From: Laura Gibbons <Laura.Gibbons@arun.gov.uk>
Sent: 19 April 2022 13:03
To: Planning.Responses <Planning.Responses@arun.gov.uk>
Cc: David Easton <David.Easton@arun.gov.uk>
Subject: RE: Planning Consultation on: P/155/21/RES

Engineers Further Comments on Surface Water Drainage

Application No:	P/155/21/RES
Registered:	15th November 2021
Site Address:	Land West of Pagham Road Pagham
Grid Reference:	488924 98195
Category:	Plan Applicat'n
Description of Works:	Approval of reserved matters (layout, scale, appearance and landscaping) following outline consent P/140/16/OUT for the 'local centre' parcel which comprises of retail, community and commercial uses, 20 No residential apartments and a 70 bed care home.

PROPOSED DRAINAGE STRATEGY

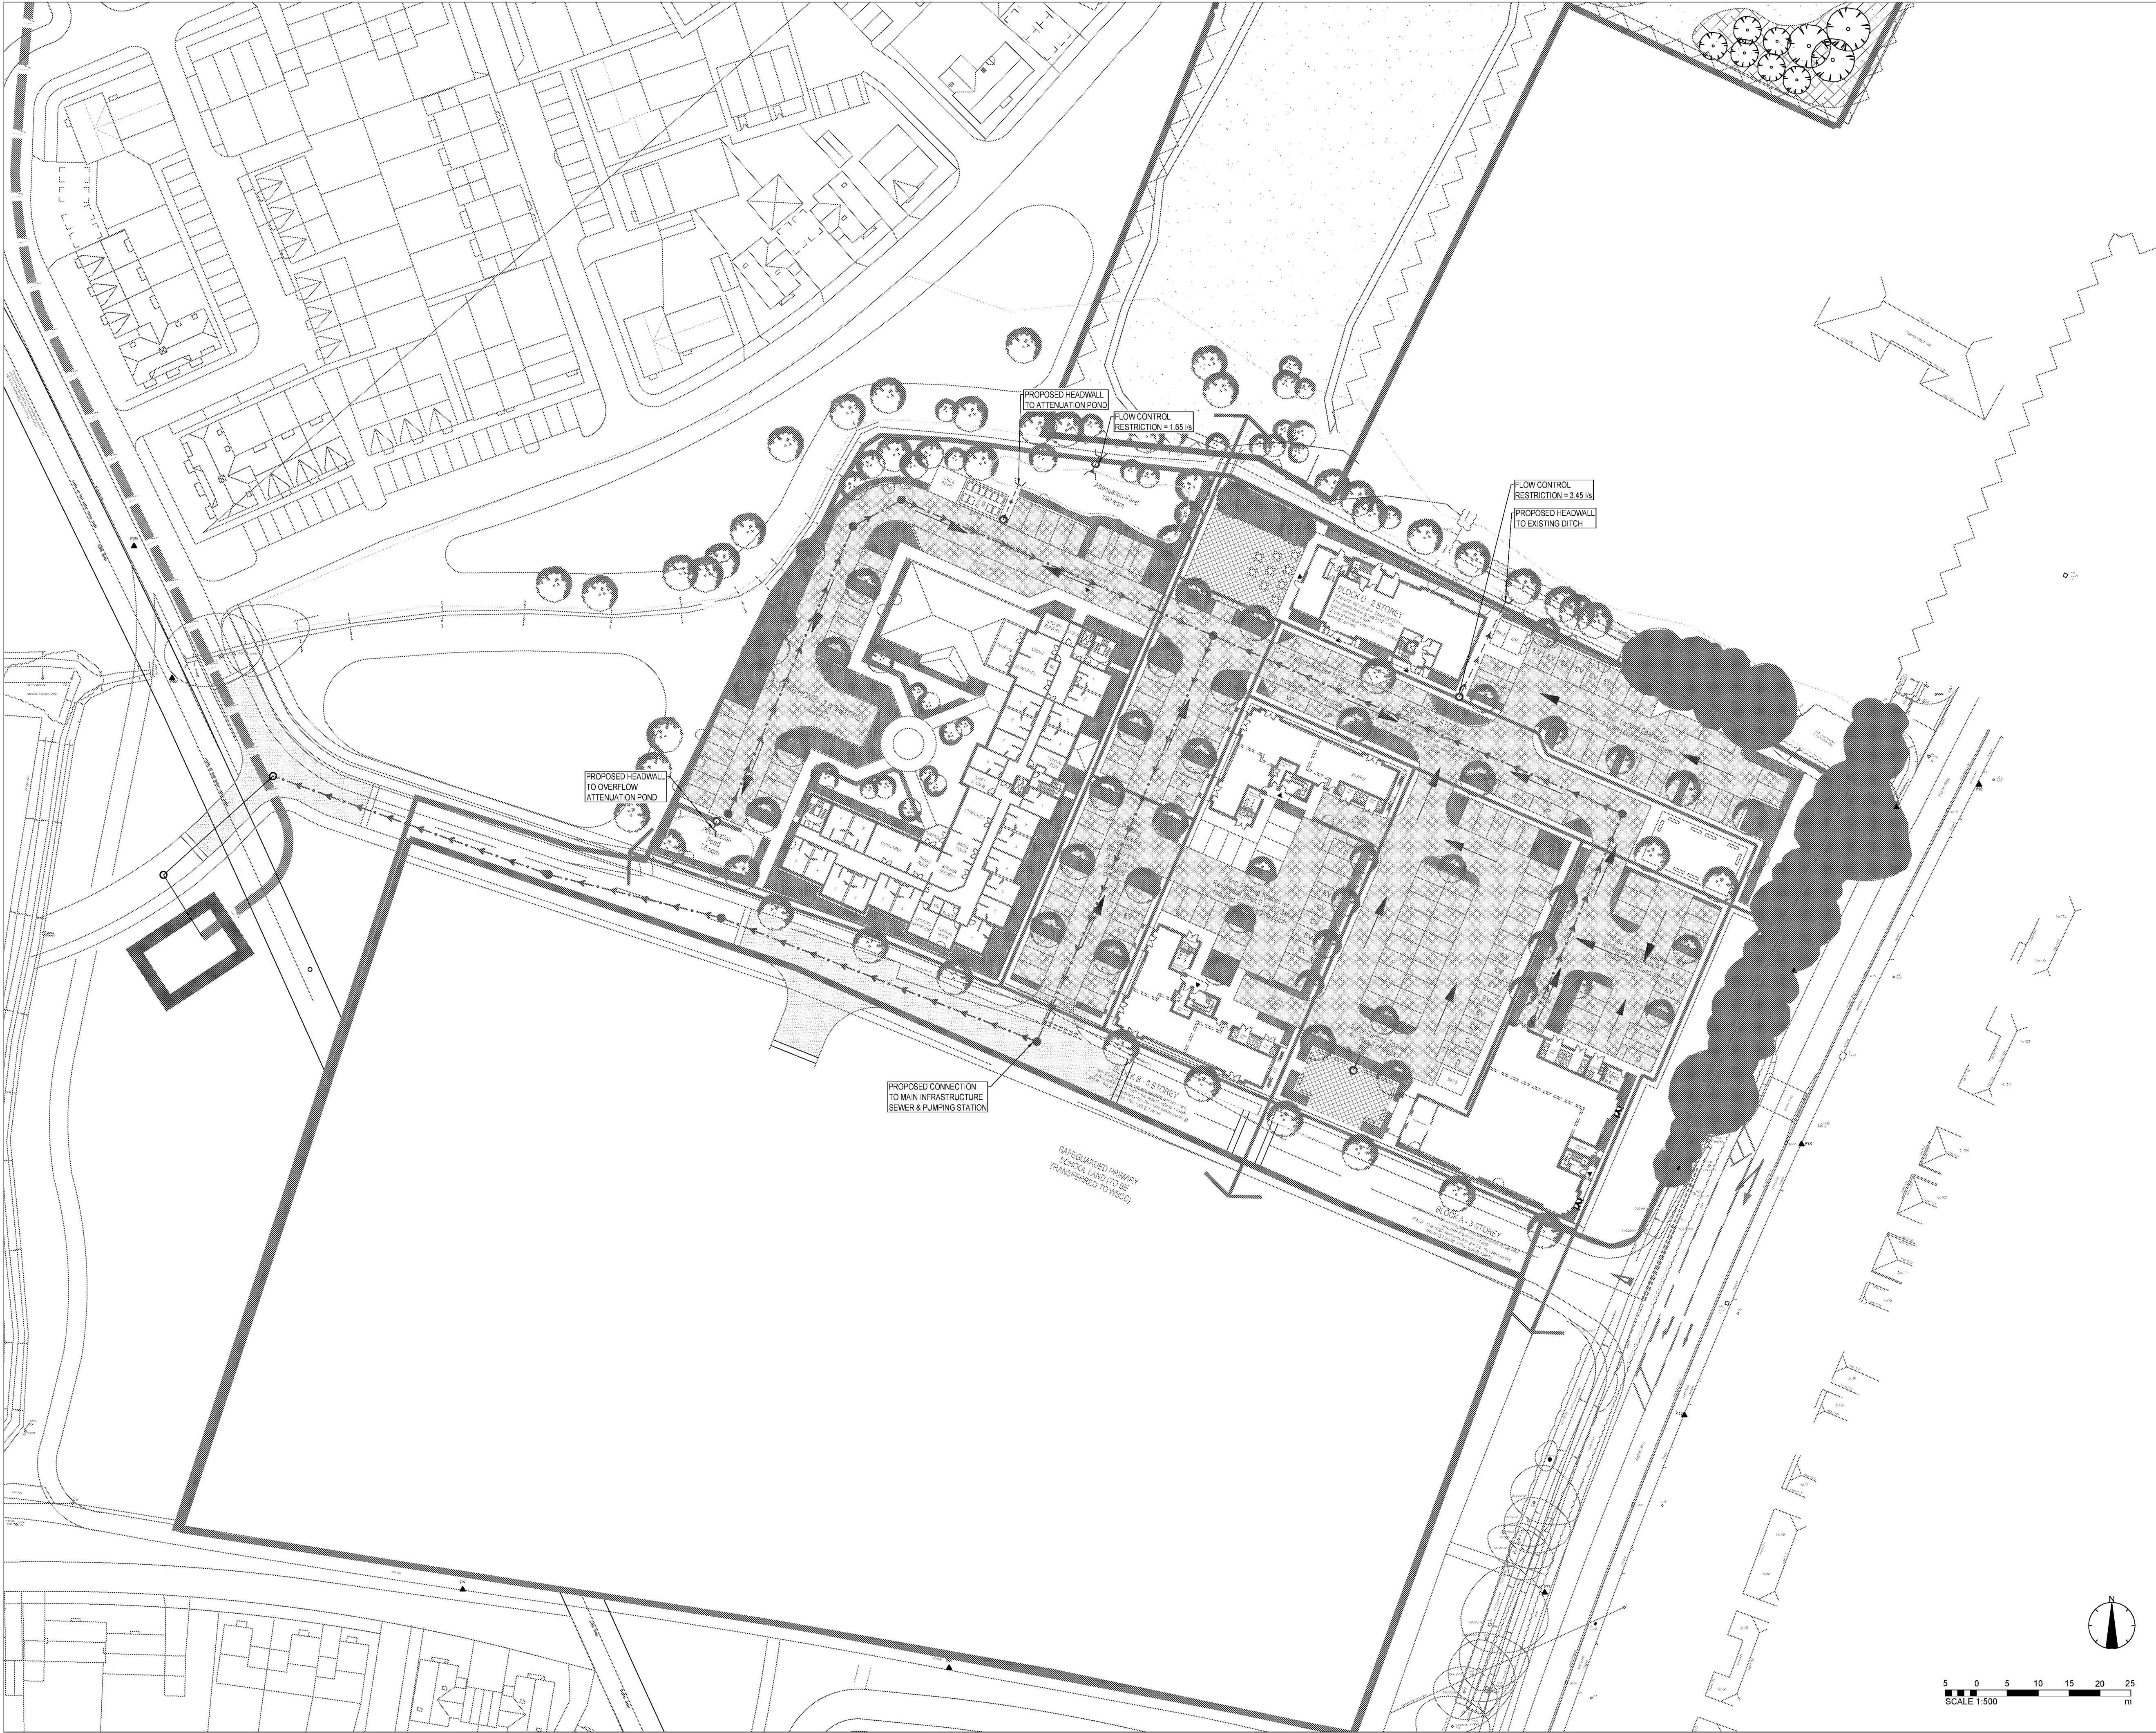
The technical note responding to our comments which were provided on 14th December 21 does not address our comments. To be clear our comments detail the level of information which is required at this stage of the application. This information is required at this stage of the application to demonstrate that in principle a policy compliant surface water drainage design will be achievable within the proposed layout.

Providing high level responses which essentially state that information will be provided at DOC stage does not meet our requirements for this reserved matters application.

Please respond fully to our comments from the 14th December with calculations and high level drainage layouts.
